From: Buczak, Maria 
Sent: 04 September 2018 12:09
To: James Kenny
Cc: David Easton
Subject: URGENT: Historic England comments on Planning Application Y/92/17/OUT
Importance: High

Planning Ref: Y/92/17/OUT
Our Ref: P00754551

Planning application Y/92/17/OUT is an outline application for 300 dwellings and associated works and landscaping at land east of Drove Lane, Yapton, BN18 0EB. The application is currently under consideration by Arun District Council; with a decision deferred until September. You gave planning advice about this application. We have been contacted by a member of the public, Julie Robinson, about her recent research into the historic significance of Drove Lane as an ancient track-way. We think you should be made aware of this so that it can be taken into account in consideration of the planning application. A copy of this letter also goes to Arun DC.

FIGURE 19. Application site plan

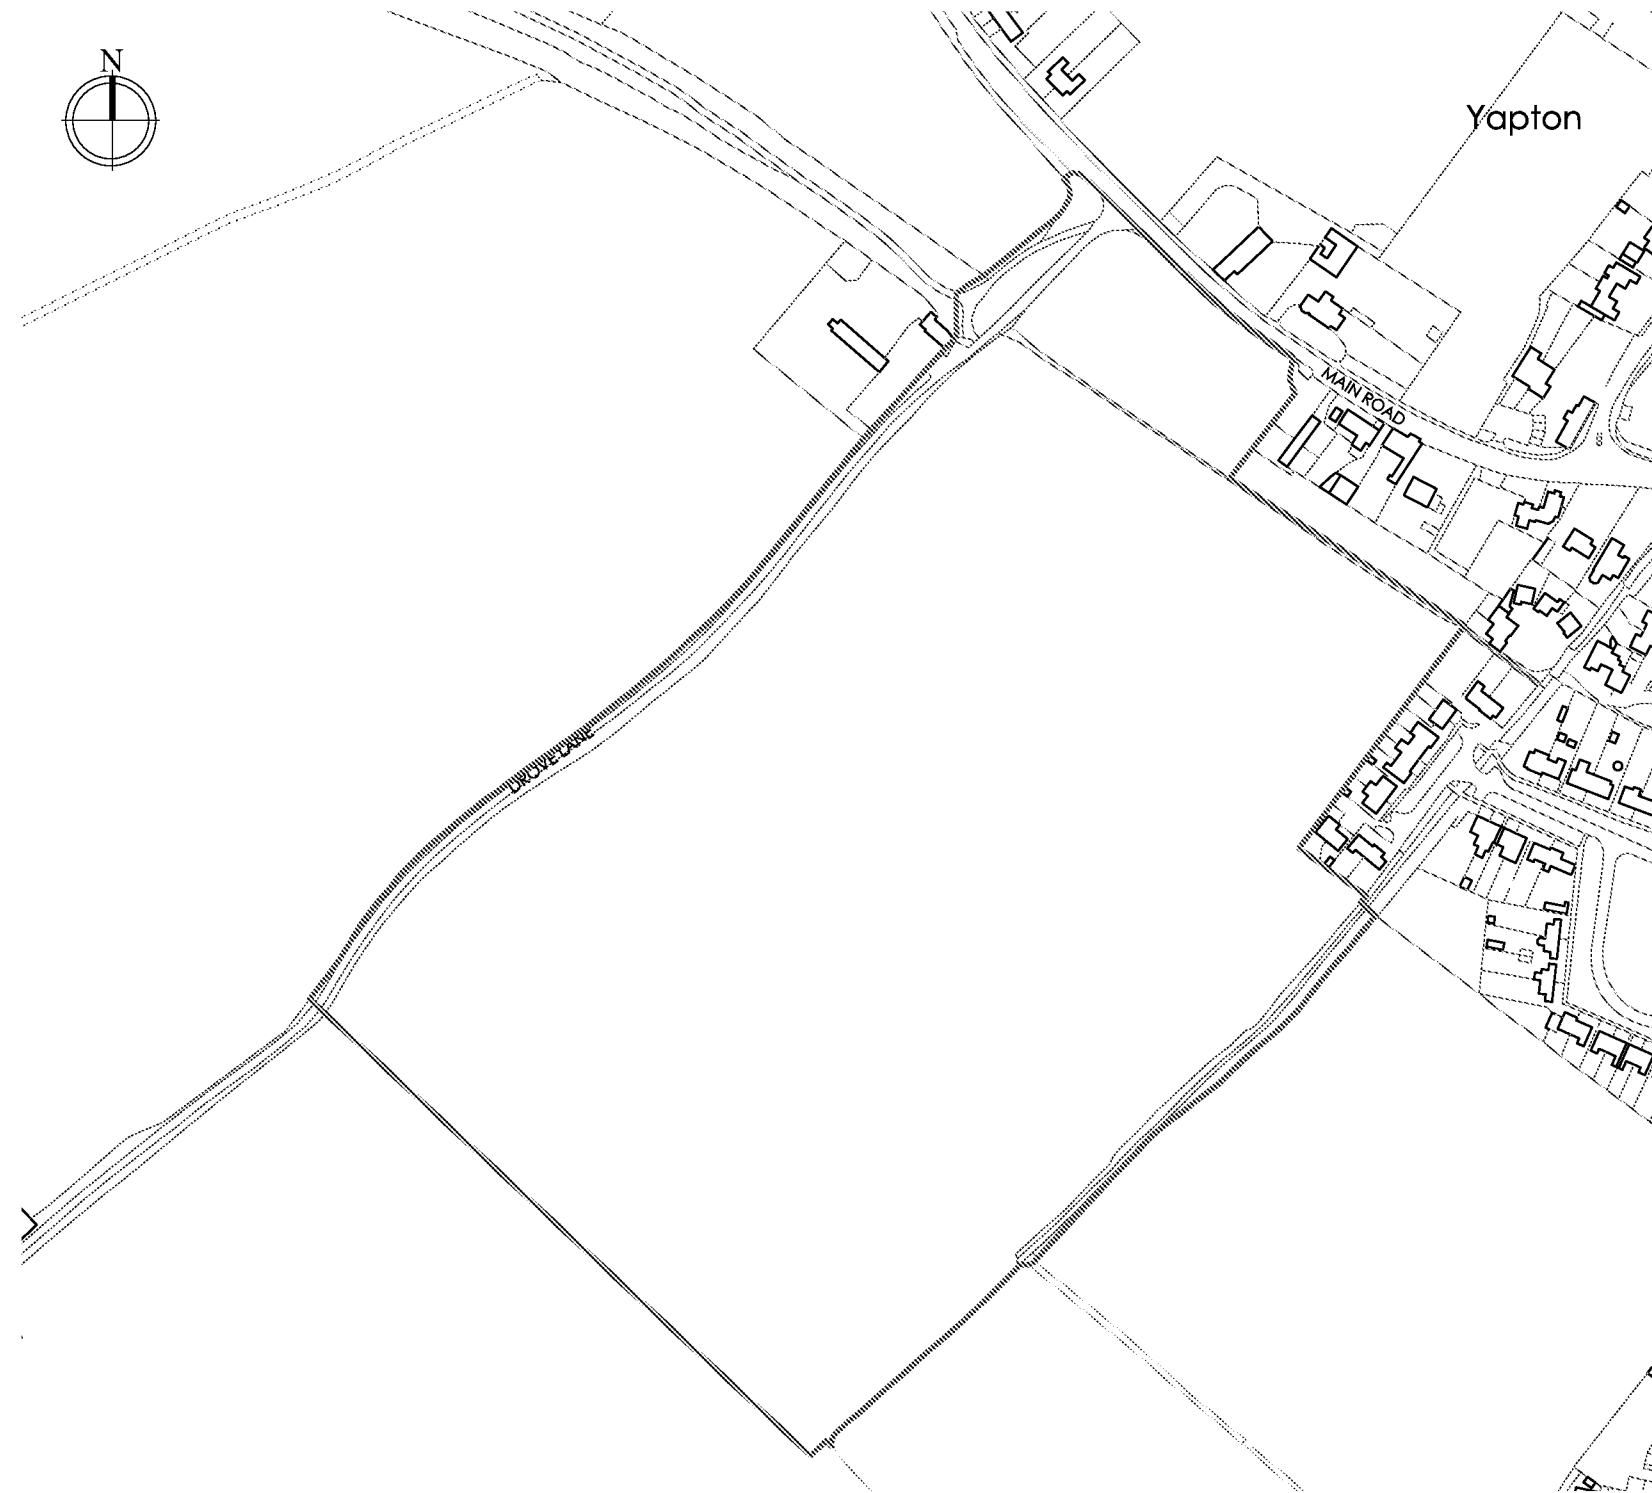
The most recent master-plan for the proposed development at Yapton (Y/92/17/OUT) does show that part of Drove Lane would be disturbed through the creation of a new access into the site, although the intention is to retain Drove Lane as a public right of

way. It may also be impacted upon by plans to landscape (e.g. plant trees) and physically upgrade the lane as a cycle/pedestrian way. This could impact both its archaeological (evidential) value; and its appearance and character, which contribute to an understanding of its significance.

The desk-based assessment (TVAS, 2017) accompanying the planning application makes no mention of the track-way and hence its heritage significance. We understand that you have recommended that a programme of archaeological investigation be added as a condition to any planning permission granted. We would therefore like to bring this heritage asset and its potential importance to your attention so that it may be included within any such programme, or so that you may otherwise advise on the best way to avoid, minimise or mitigate harm to it; as you see fit.
